Airport Industrial Property Unit Trust ('AIPUT') hereby provides a brief Deadline 2 submission relating to the examination of the application made by Gatwick Airport Limited ('GAL') for a development consent order ('the DCO application') for the Gatwick Northern Runway Project ('the Project') under the Planning Act 2008 ('PA 2008').

REVIEW OF GATWICK AIRPORT LIMITED'S (GAL) DEADLINE 1 SUBMISSIONS

Surface Access Highways Plans – Structure Section Drawings – For Approval

Project Code-Location-Discipline-Volume-Type-Unique Number
41700- XX -B- LLO- GA - 200172 P01

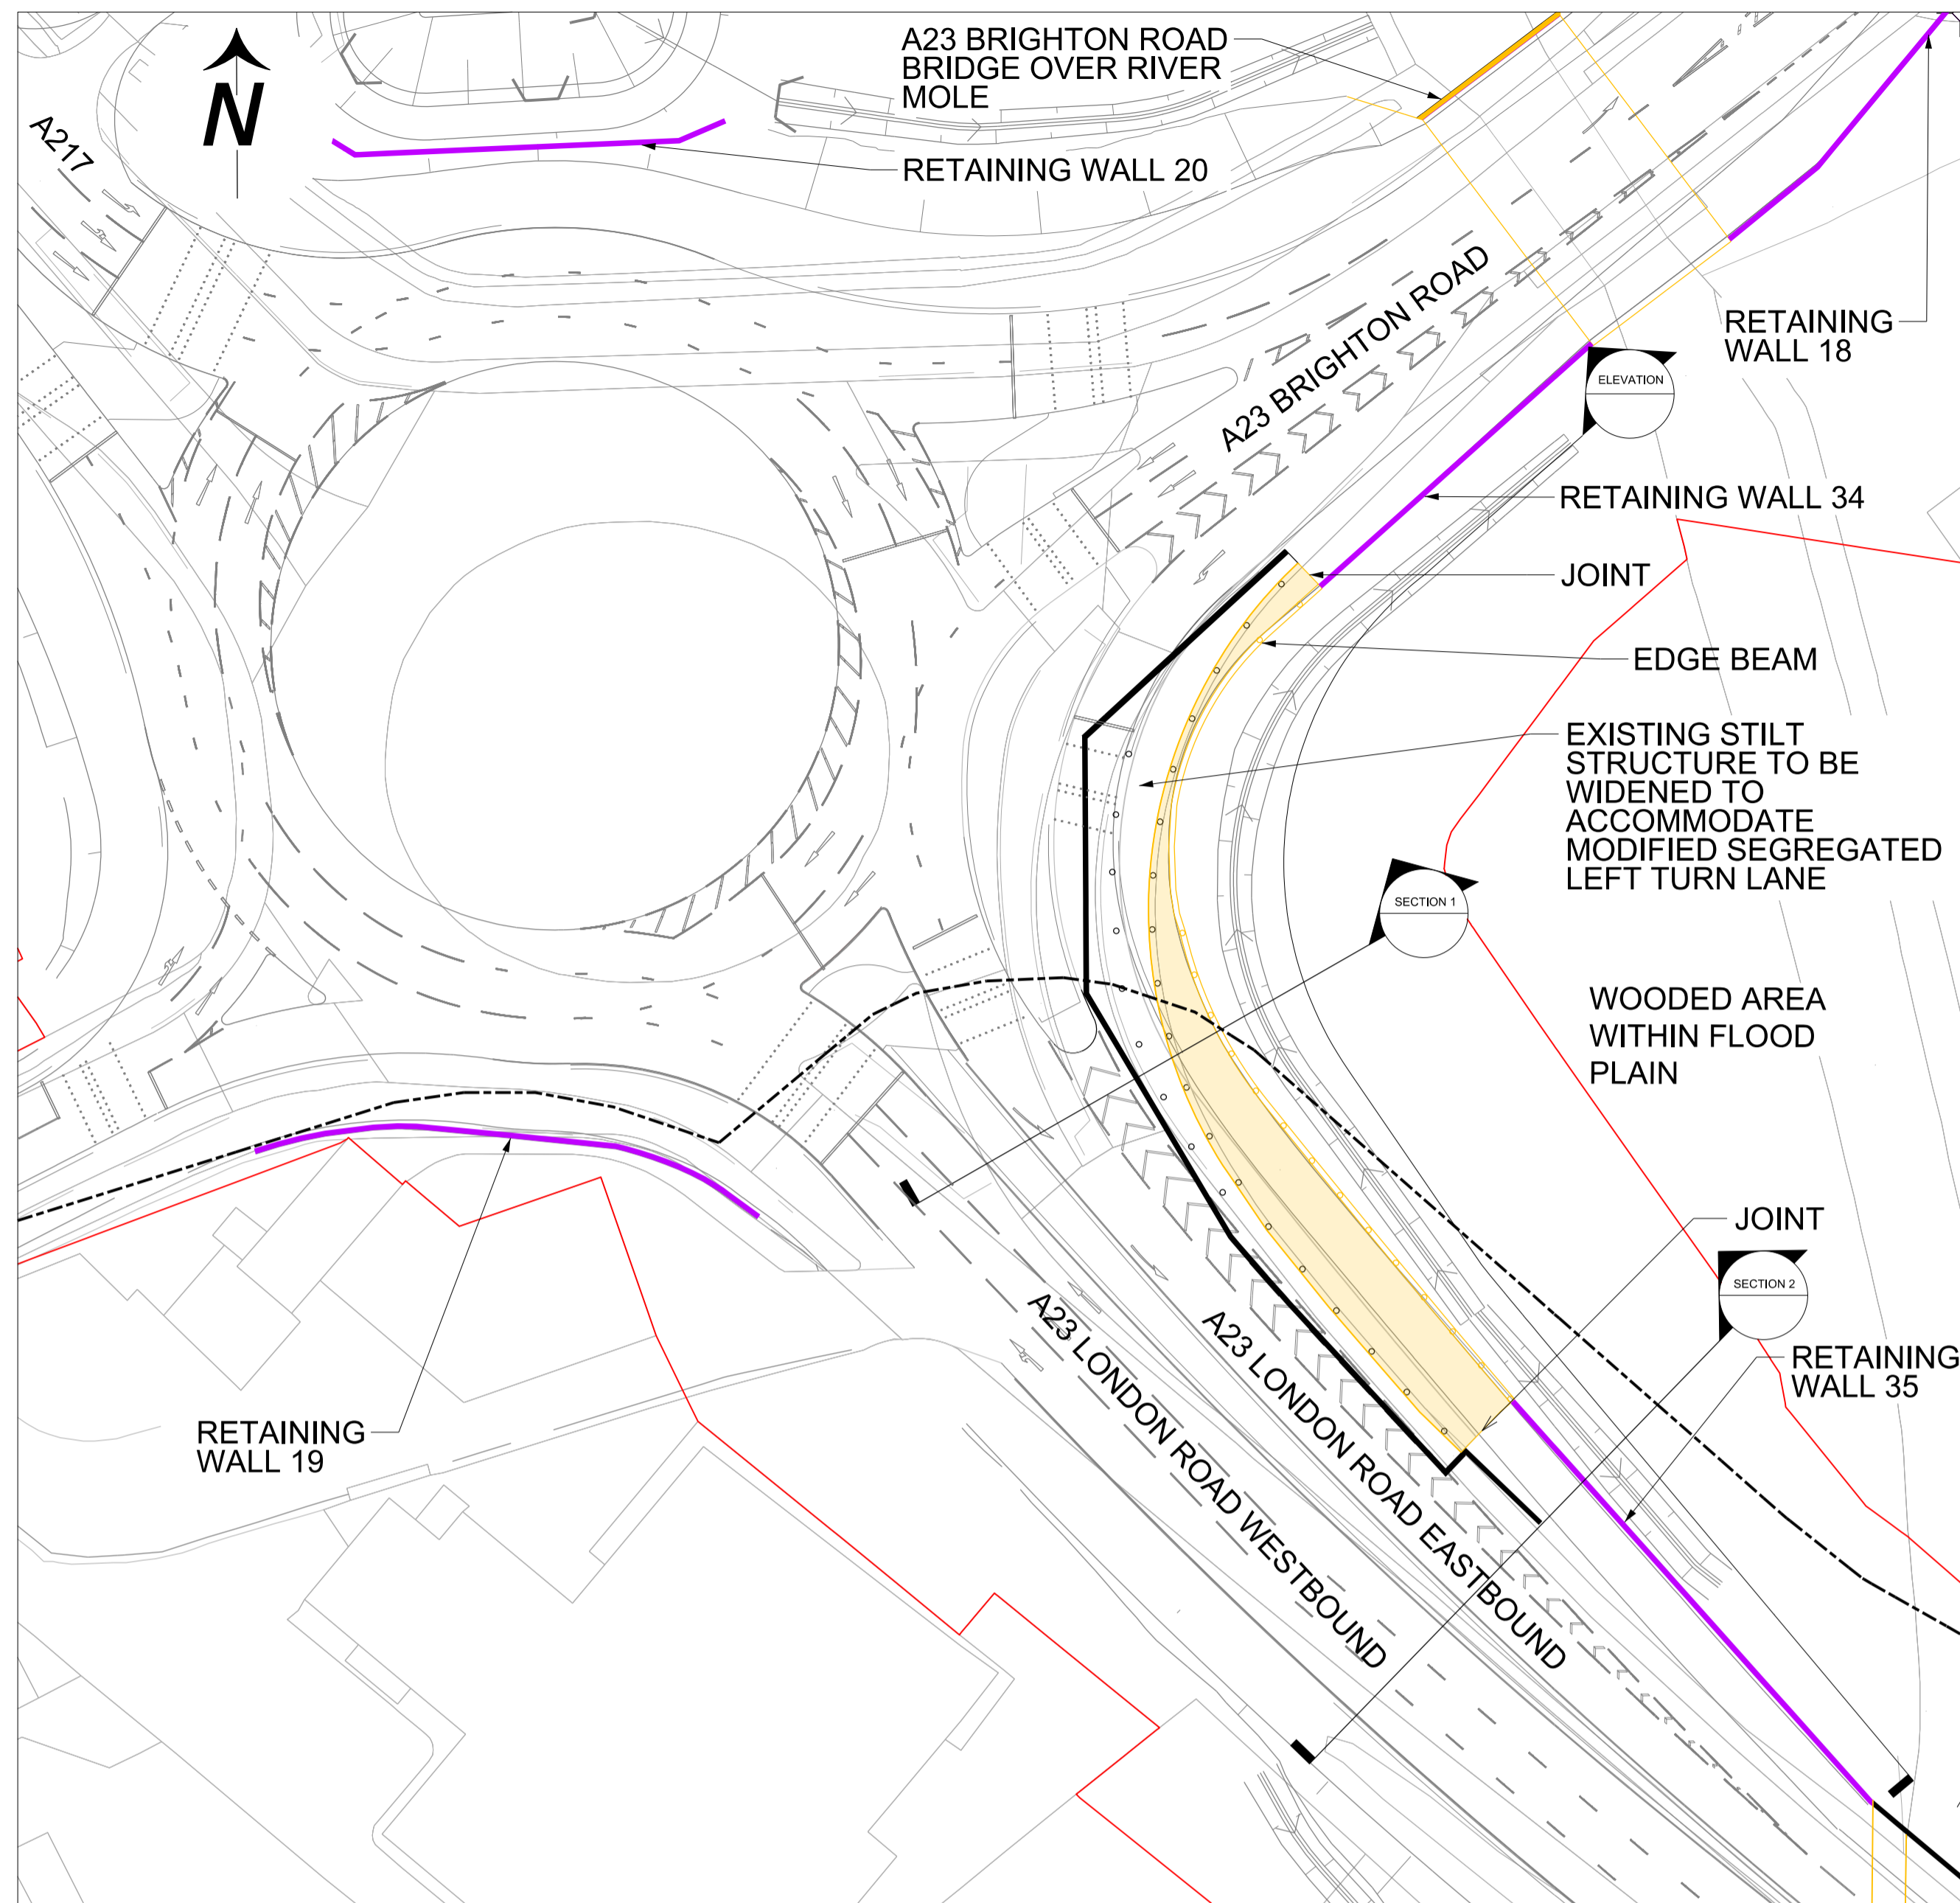
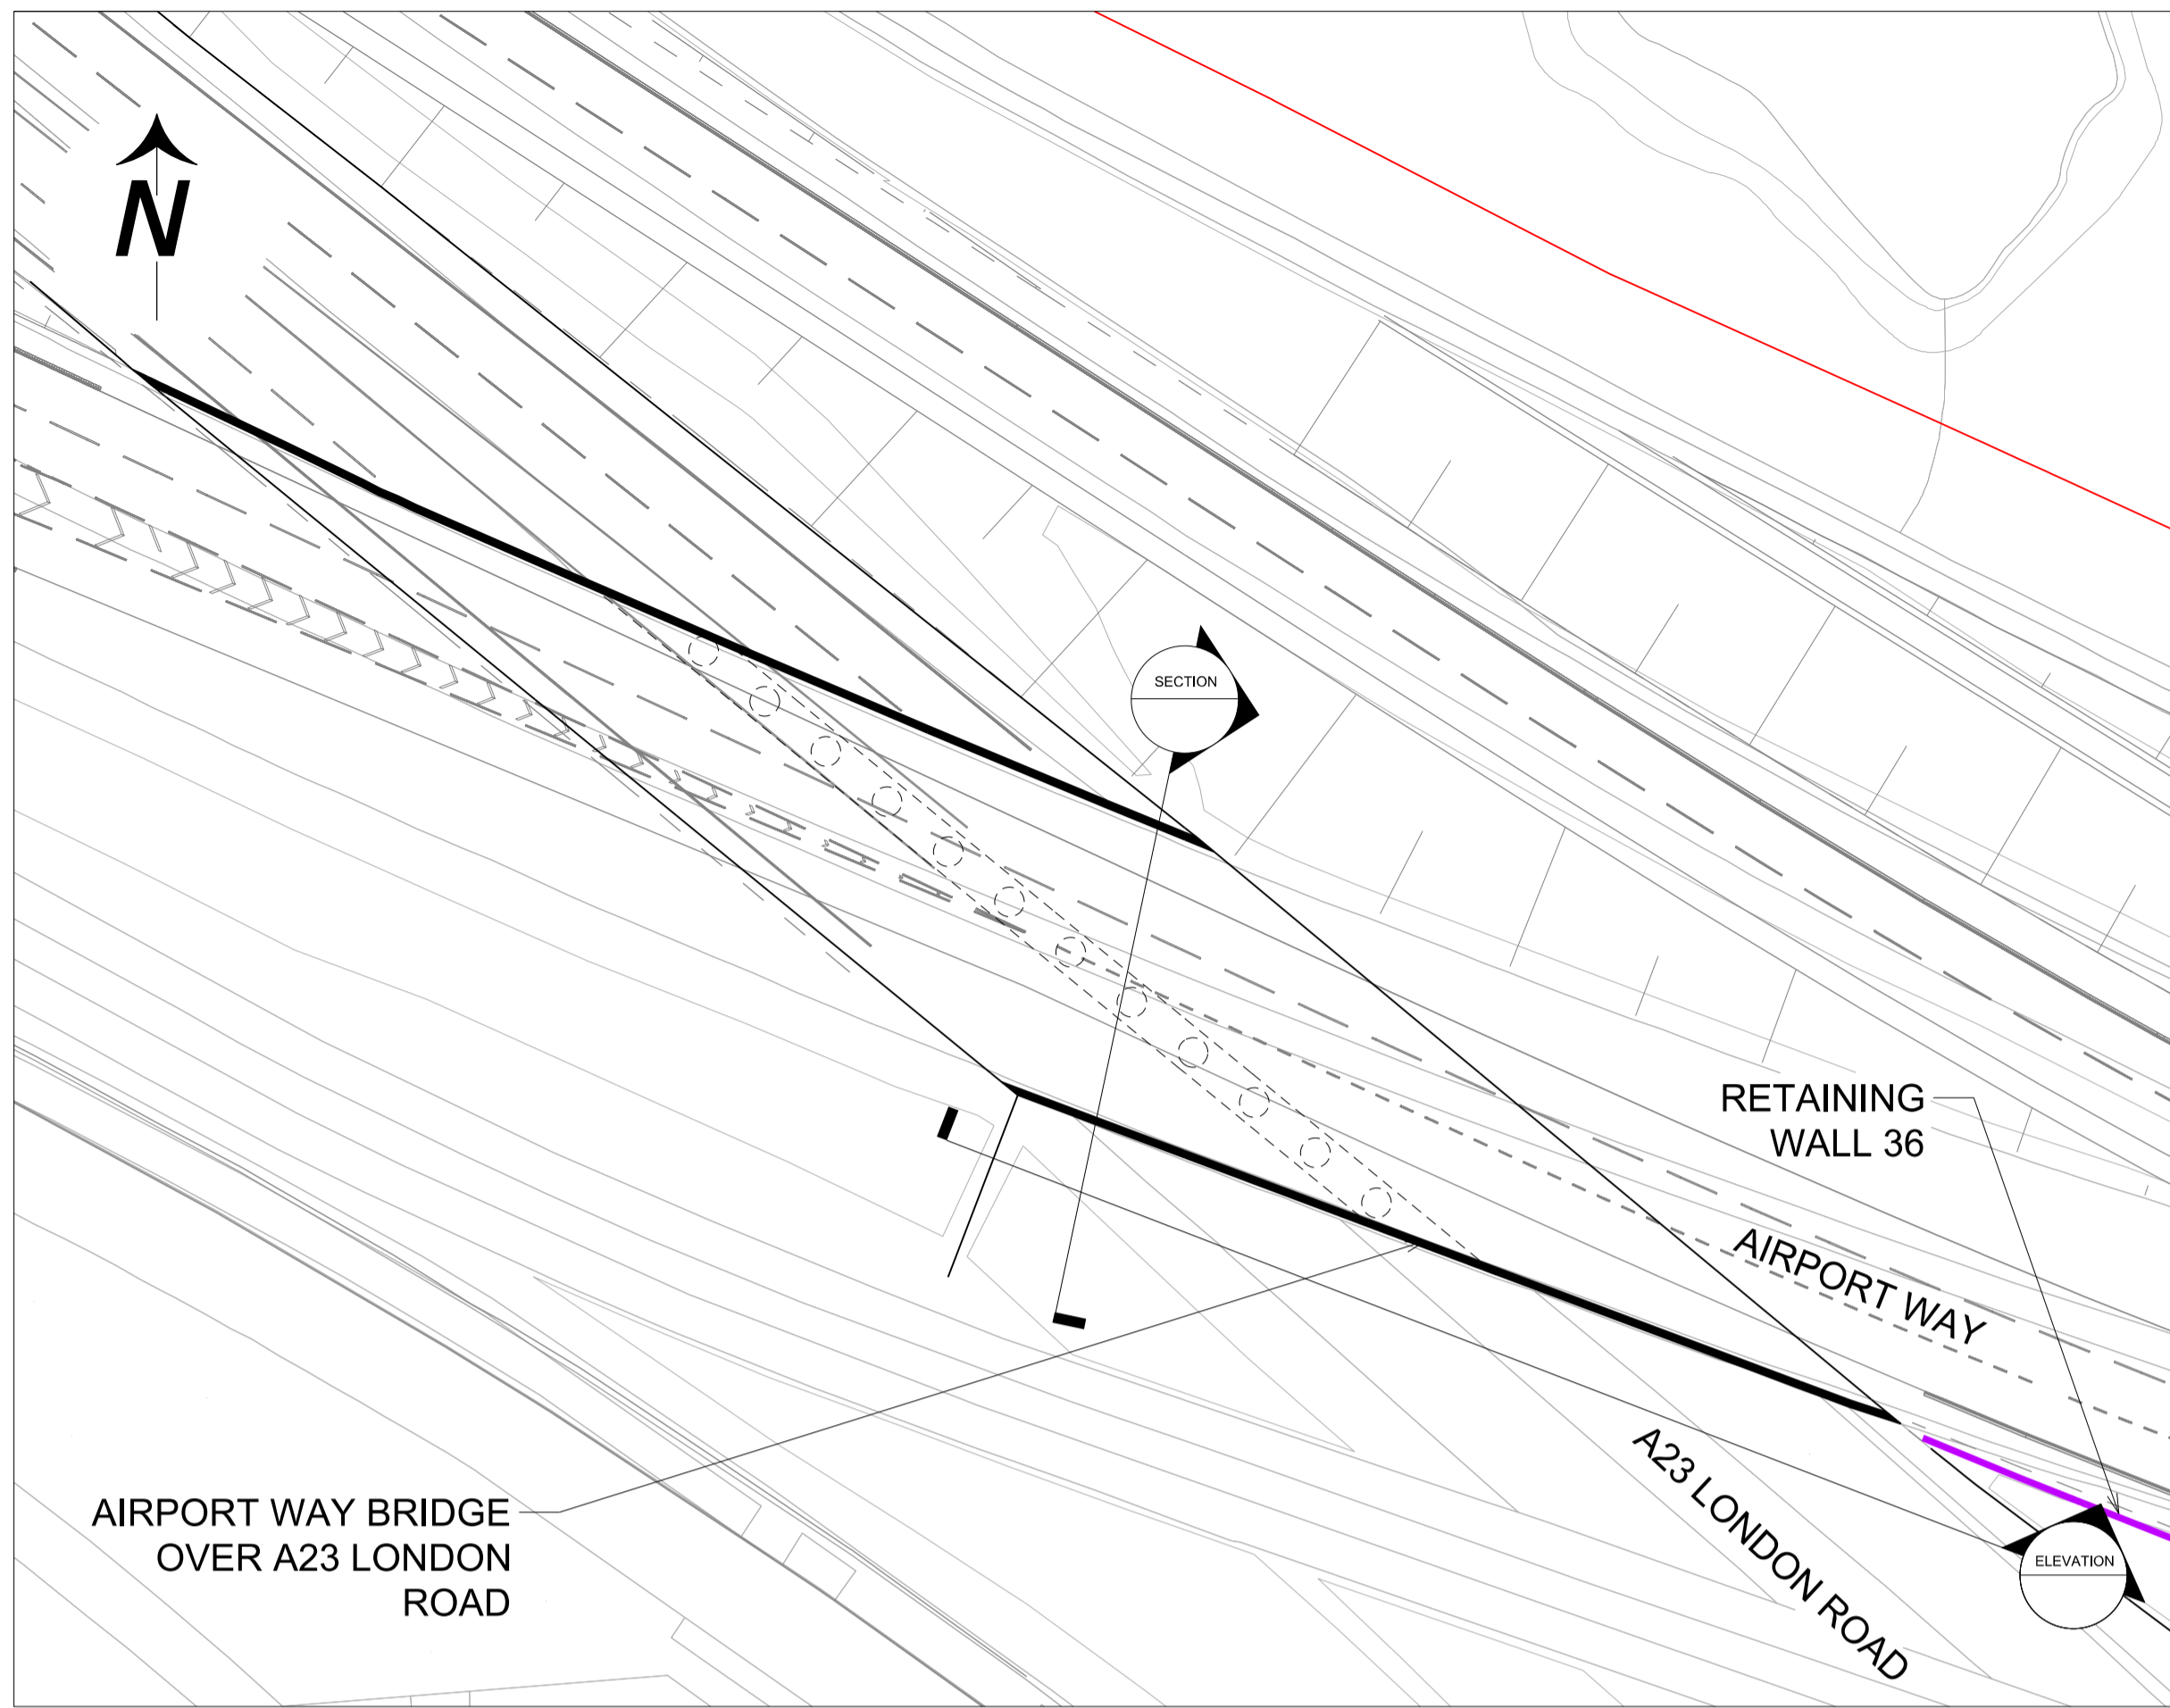
The structure section drawings are welcomed by AIPUT and provide some detail to the surface access highway plans being proposed. Motion would like to query on behalf of AIPUT, how the lane widths have been determined. For instance, the two-way single carriage ways are labelled as 7.25m despite a width of 7.3m being the established DMRB requirement, suggesting unfamiliarity with DMRB. AIPUT would also request that dimensioned plans are provided for junctions across the highway network.
